DEVIATION REQUEST AND DECISION FORM

Project Name : Eagleview Subdivision
 Schedule No.(s) : 5226000001, 5226000001
 Legal Description : N2NW4 EX WLY 620.0 FT SEC 26-12-65,S2NW4 EX WLY 620.0 FT SEC 26-12-65

A deviation from the standards of or in Sections **2.3.8.A** of the Engineering Criteria Manual (ECM) is requested.

2.3.8.A Roadway Terminations - Cul-de-Sacs

Exhibit 1
Deviation No. 2*
 Eagleview Subdivision (LSC# S214750)

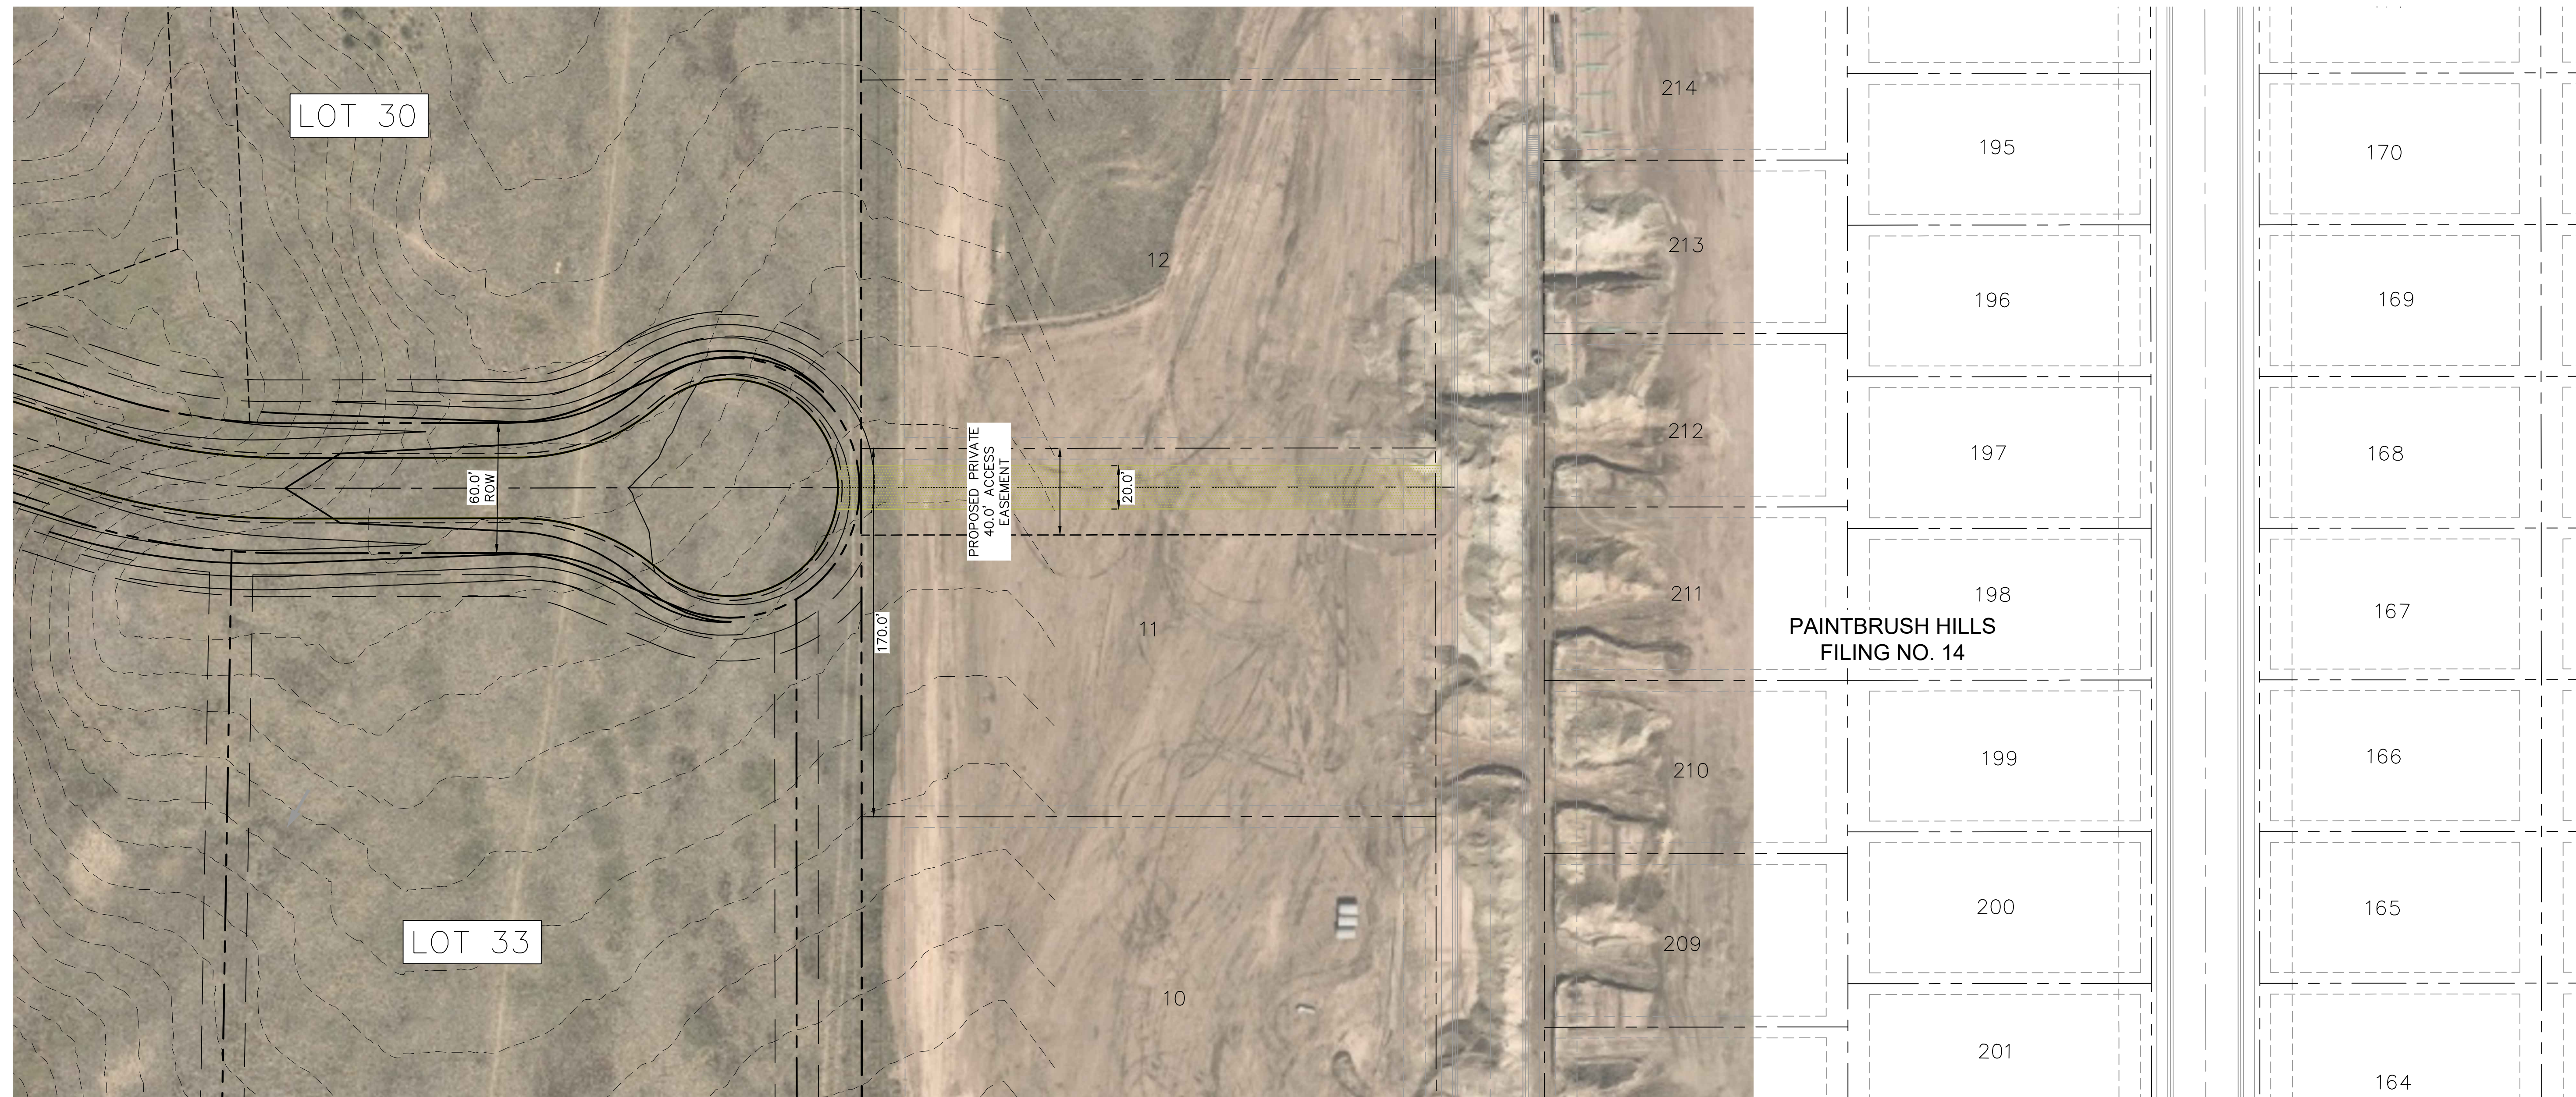
Update cul-de-sac names per the preliminary plan

A secondary emergency access is required. The applicant needs to approach the developer of Paintbrush Hills Fil 14 to acquire a temporary access easement for a secondary emergency only access or any other land owner in the vicinity such as the church property to the south west the property to the west on Arroya Ln to may be able to provide a secondary emergency access.

remove 1st bullet point. Letter must be included with the deviation request

Identify the timing for these future connection.

The applicant has proposed to construct a secondary emergency access for the neighborhood, from Stapleton Drive to the extension of Keating Drive, in Paint Brush Hills Filing No. 11. The property owner directly to the south of Stapleton Drive has provided a letter indicating that it will be acceptable to construct this road on their property. Final details for the proposed emergency access road, including roadway design criteria, drainage crossing design, easement requirements, and gate location(s) (if any), will be determined at the Final Plat stage. Staff would not support waiver # 3 without this emergency access constructed, due to the number of lots served by the single Raygor Road access.
